Application No: K/55/20/PL
Site Address: 57 Coastal Road Kingston BN16 1SN
Description of works: Demolition & erection of 1 No. dwelling. This application is in CIL Zone 4 and is CIL Liable as new dwelling.

Thank you for your internet representation made on 22nd January 2021 which has been recorded as an objection with the comments as follows:

For ST Charles Homes LTD	
Drawing Proposed Plans&Elevations	
Project La Casa, 57 Coastal Road, West Kingston East Preston BN16 1SN	
Scale	1:100
Date	19.11.2020
Made by Arch. Grygorieva A.A.

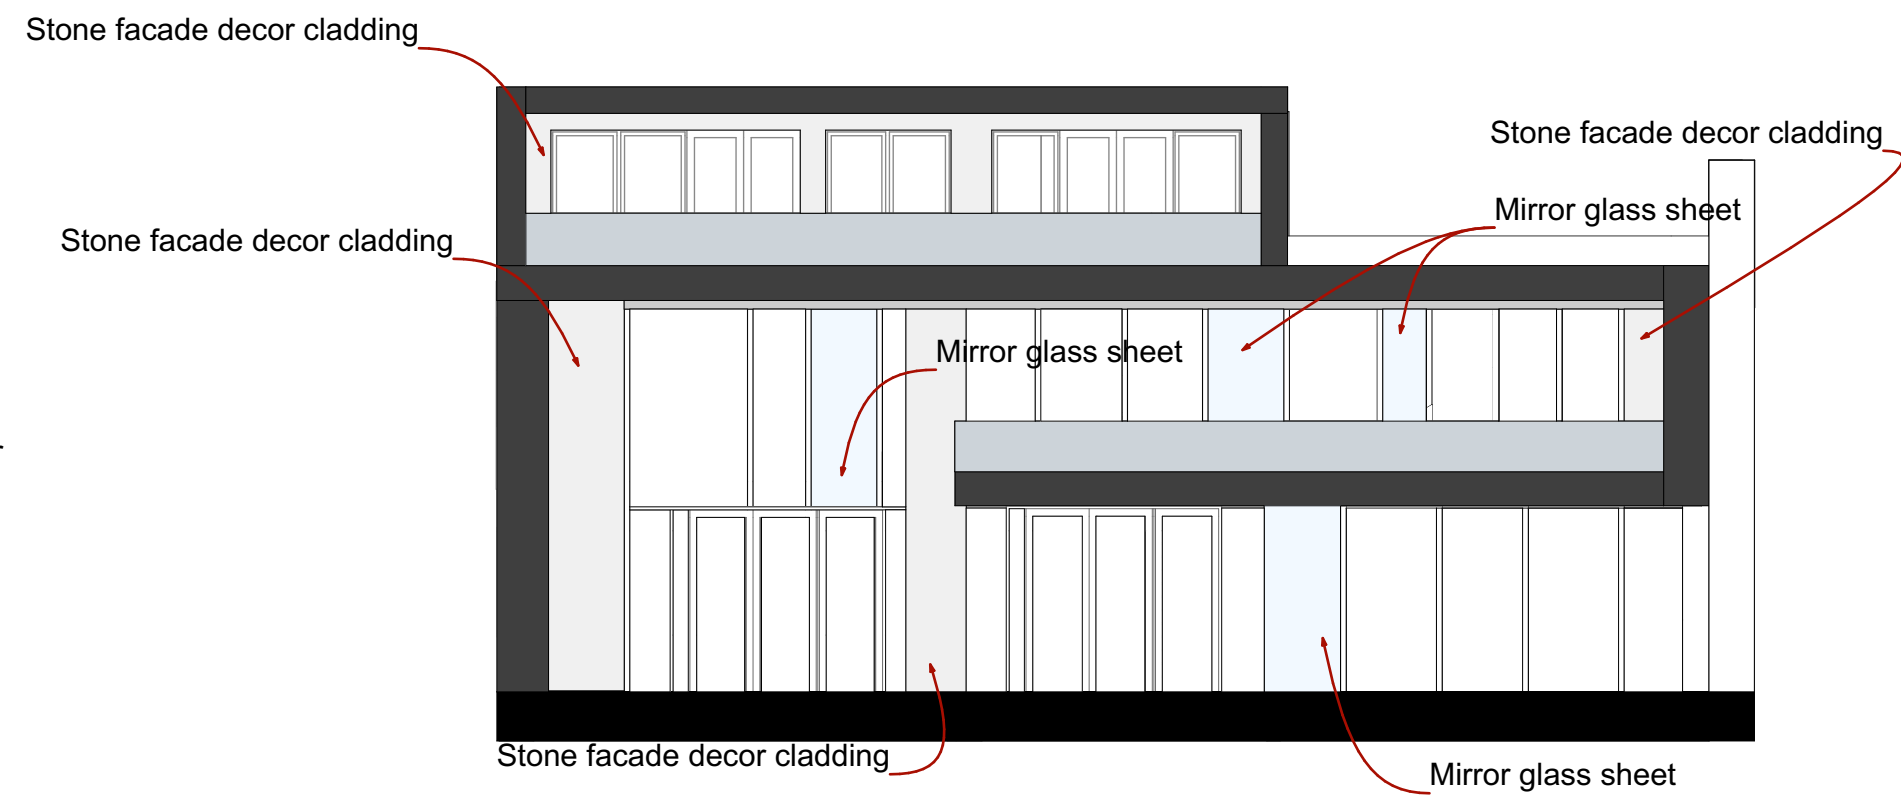
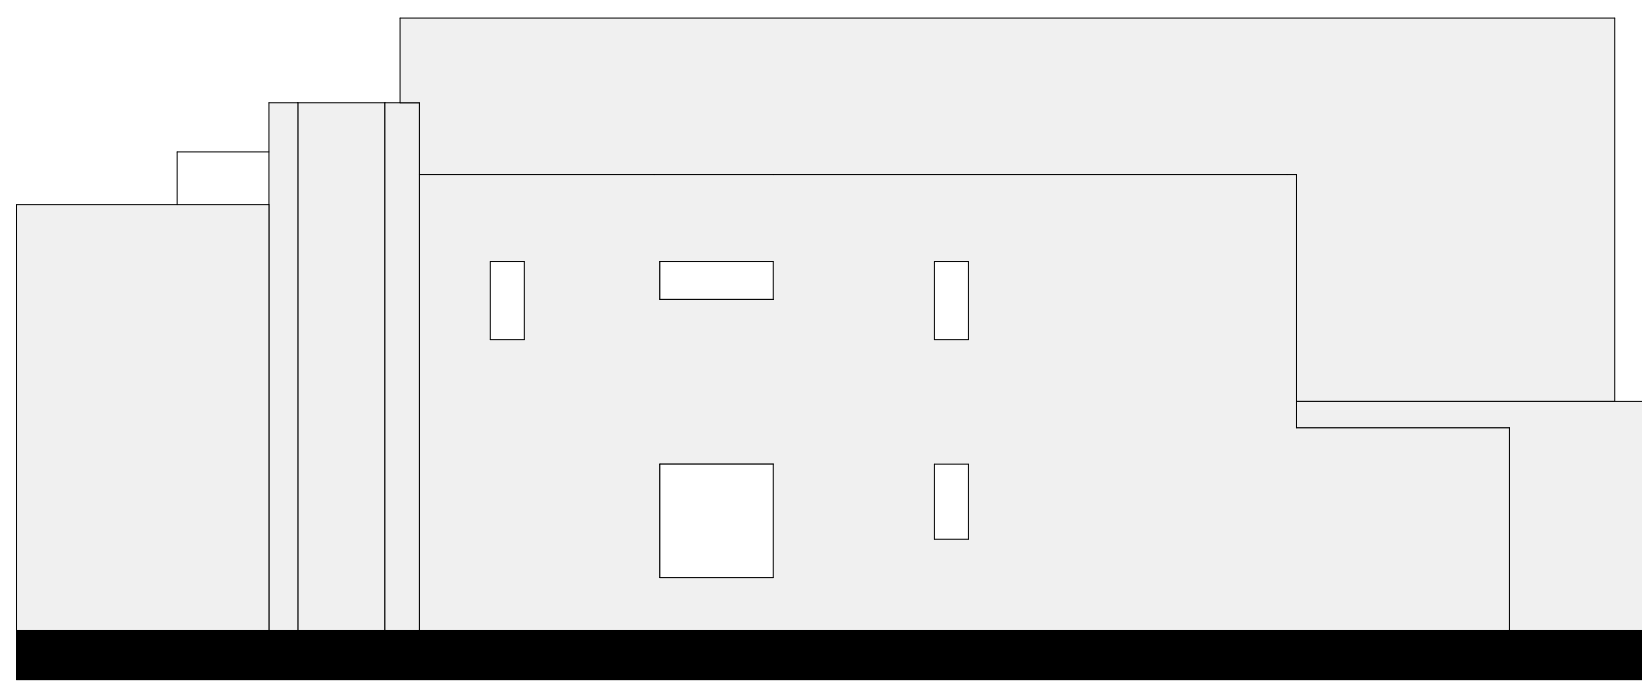
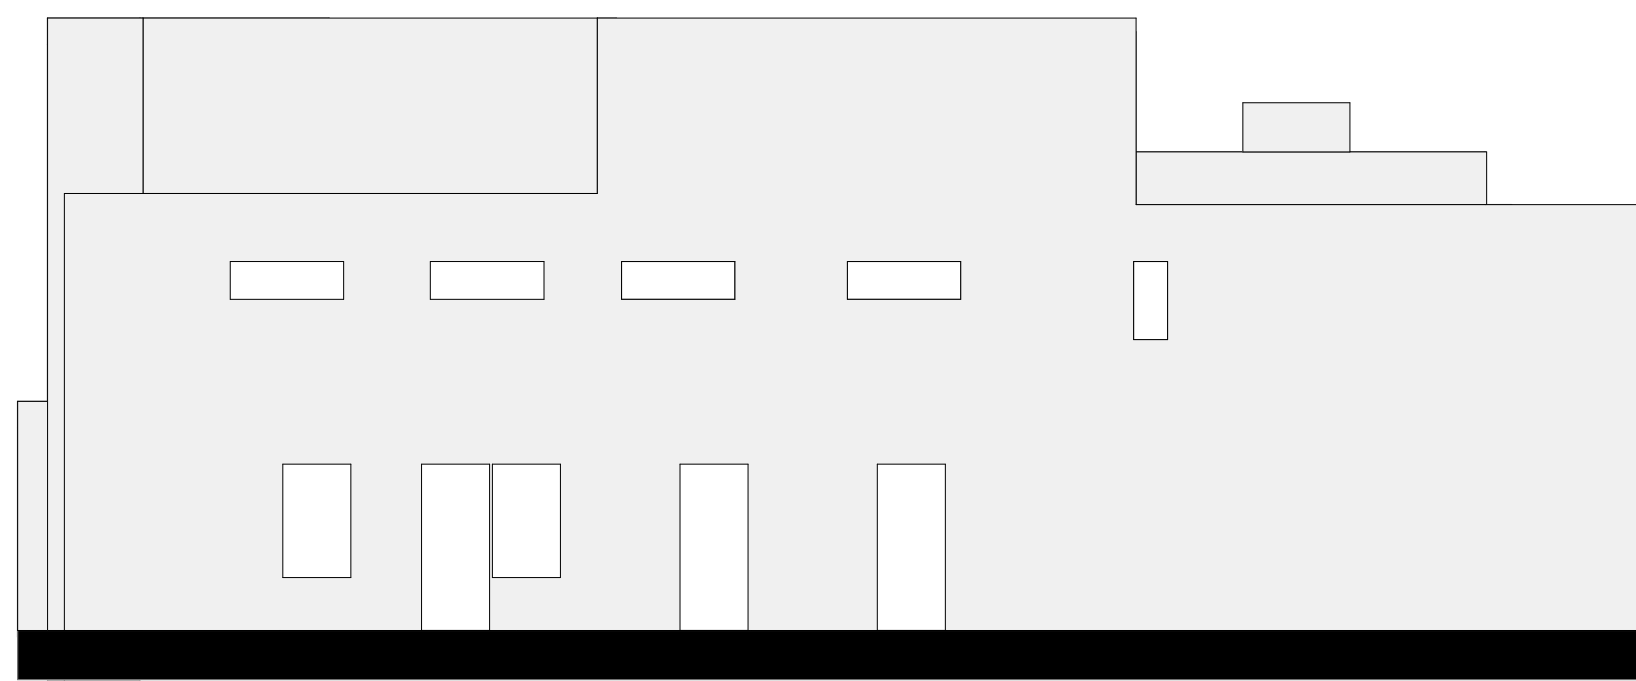
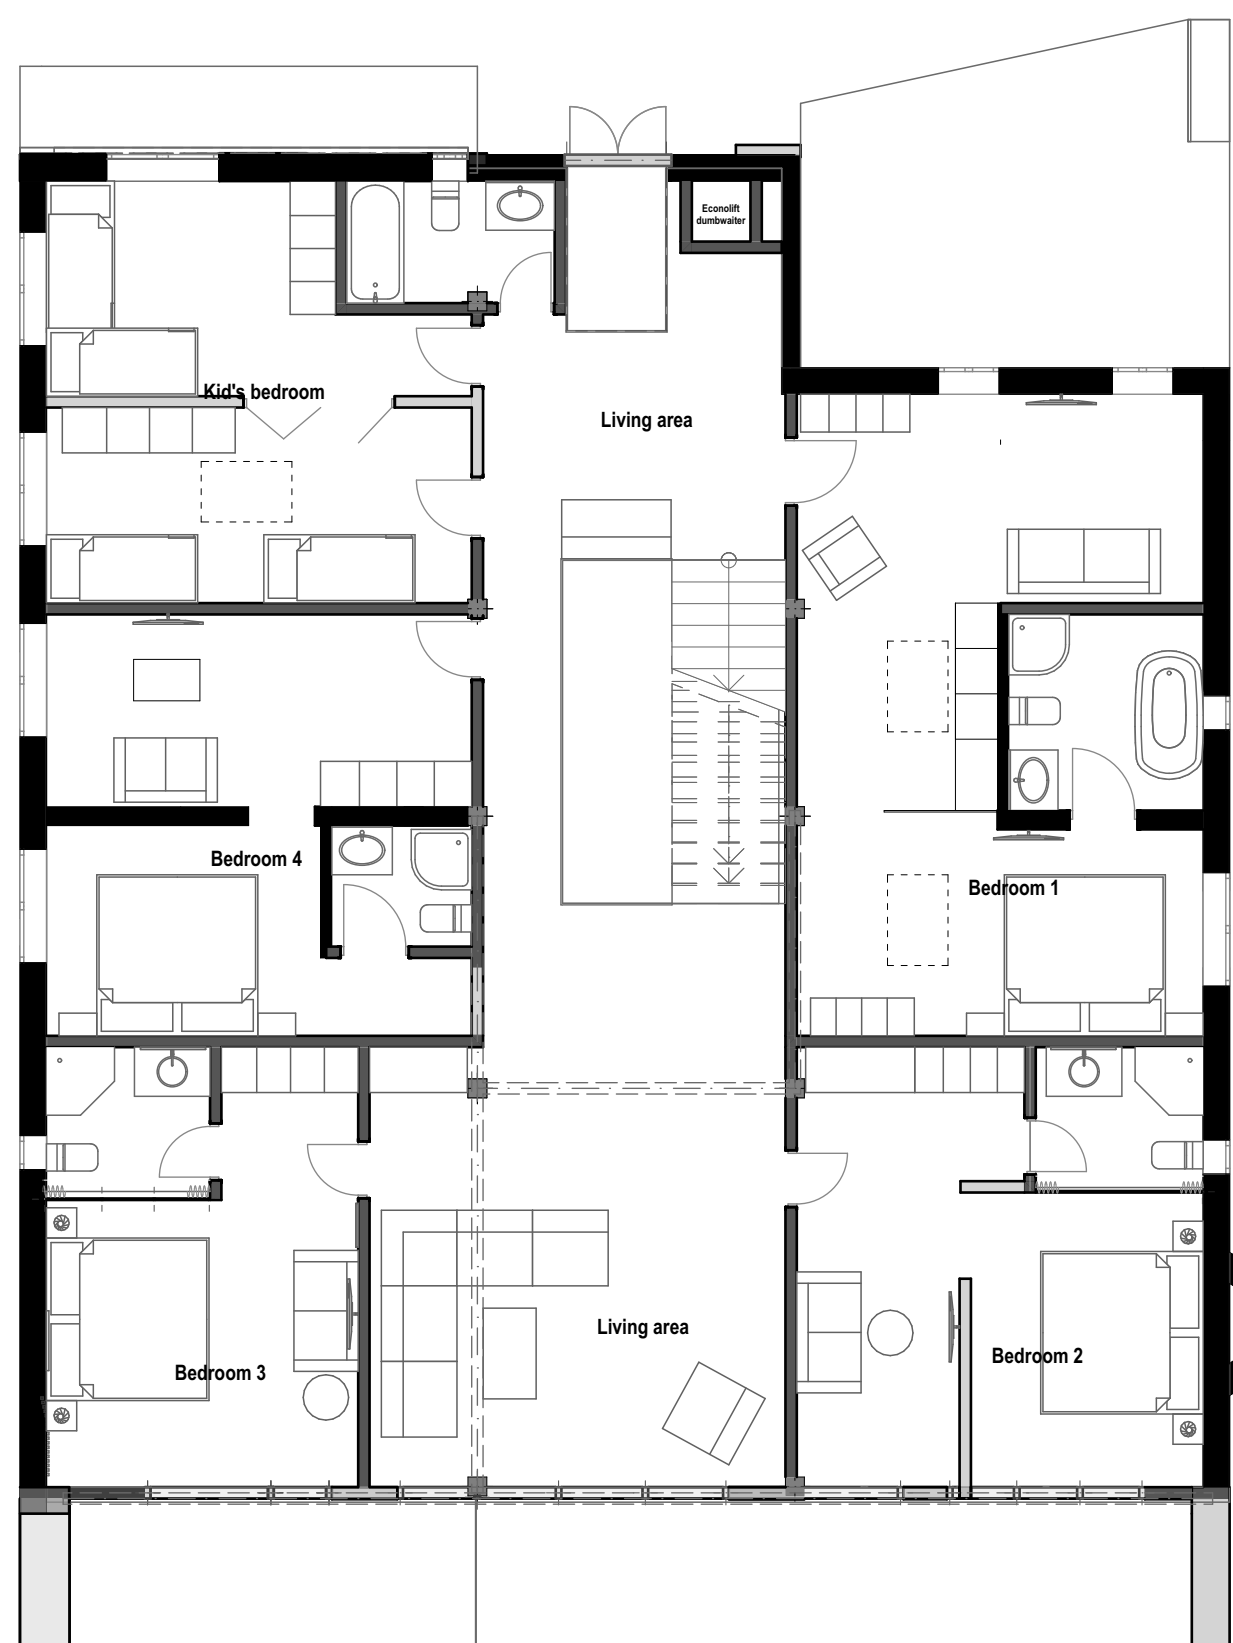
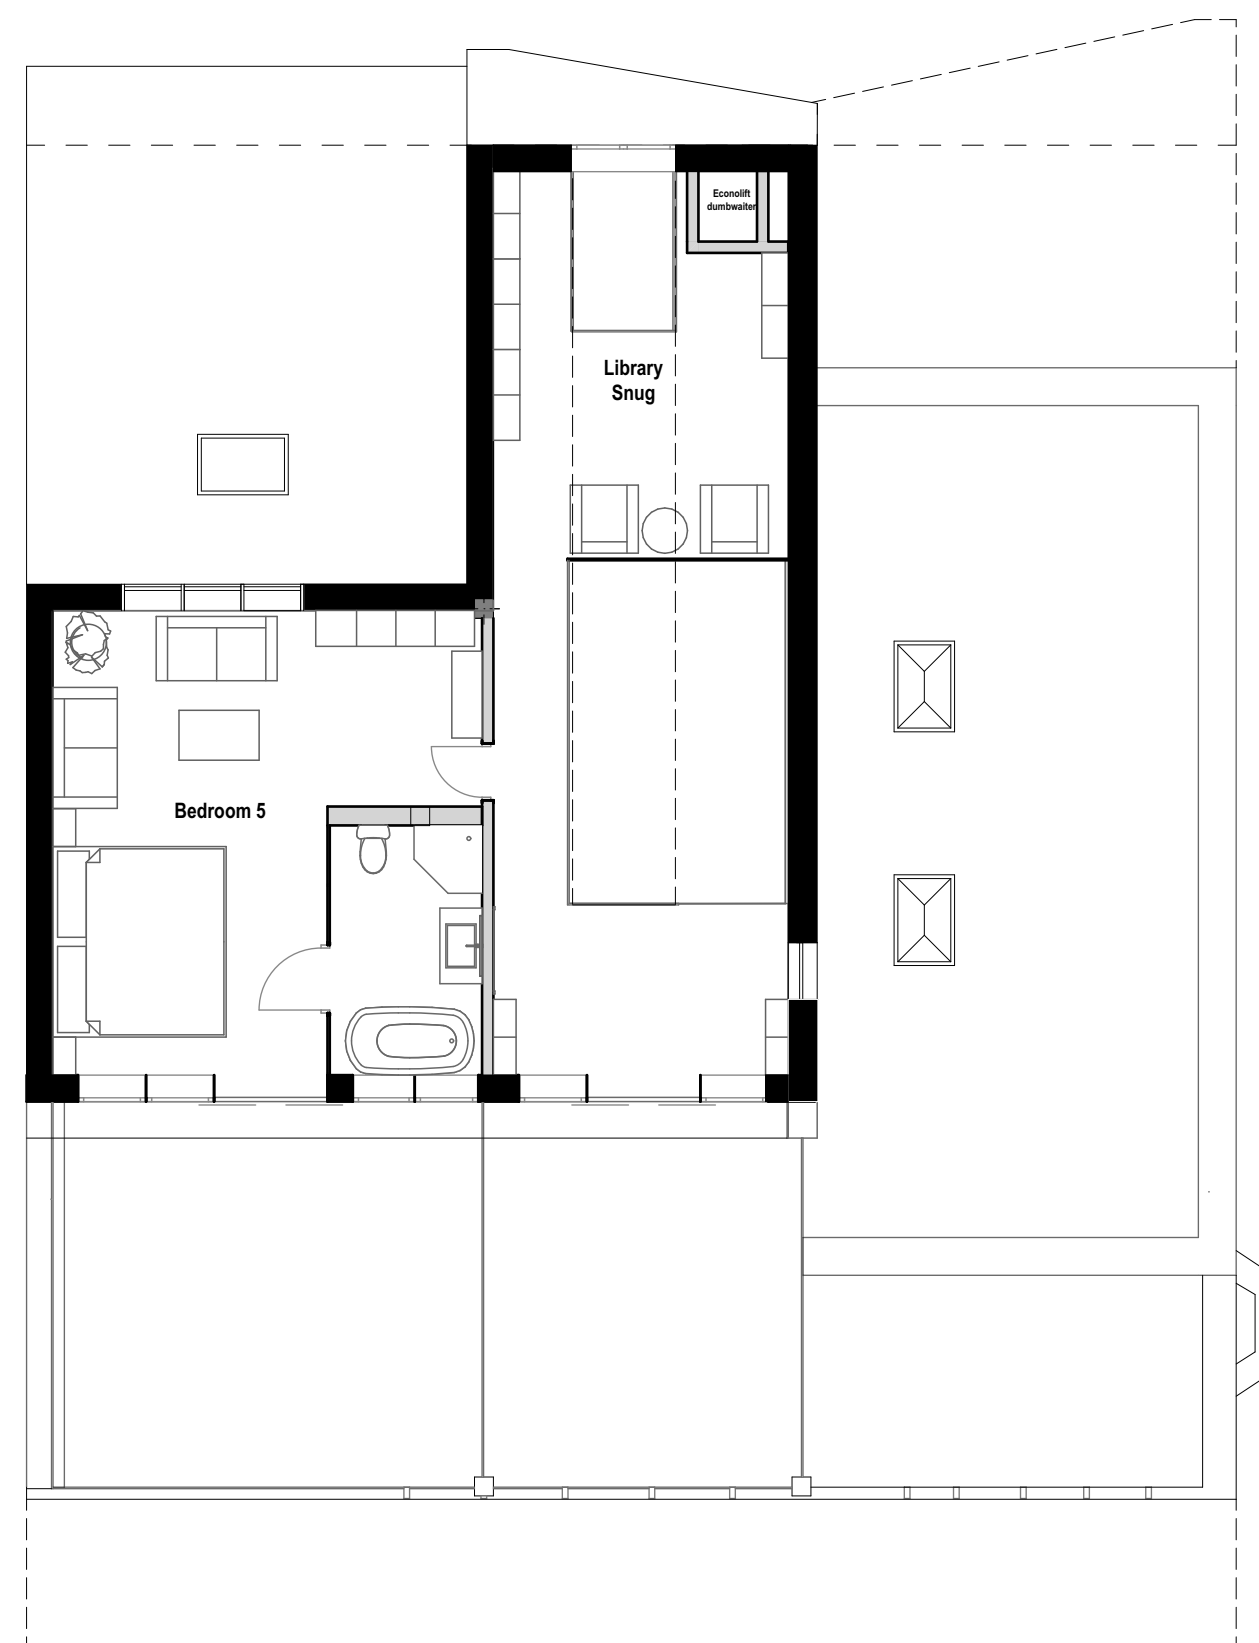
The proposed plans and elevations dated 19.11.2020 also incorrectly reference the east and west elevations and the Design and Access Statement incorrectly refers to detail associated with new first floor windows proposed on the new dwelling which will directly overlook no. 59 Coastal Road. Paragraph 4.3 states 'There would be two clear-glazed side facing windows on the western elevation facing toward no. 59. Side elevation appears to contain 2 windows, 1 serving a small bedroom and 2 side secondary windows serving the master

bedroom'. This is totally incorrect. The first floor layout drawings actually show a proposal to introduce four habitable room windows in the western side elevation which will overlook no. 59, as well as a proposed bathroom window. It should be noted that no. 59 has three habitable room windows in its side elevation at ground level facing the application site. Indeed the first section of paragraph 4.3 recognises that first floor windows are likely to give rise to overlooking and this is proposed to be addressed by these relating to en-suites 'which will be conditioned and proposed to be obscure glazed to protect the privacy of existing neighbouring residents and future occupants of the property.' However, as stated above, these are not solely serving en-suite facilities.

The Applicants' details also indicate that the second floor will be recessed in the site away from the current footprint but it is unclear from the layout drawing and elevations how this is achieved. The introduction of the extensive depth of development at first floor and the addition of the second floor creates an oppressive built form right up close to the western boundary, creating a sense of enclosure, overshadowing and loss of sunlight to the neighbouring property having regard to orientation and where receipt of morning sunlight in particular to no. 59 will be impacted. No sunlight/daylight assessments have been included to demonstrate otherwise.
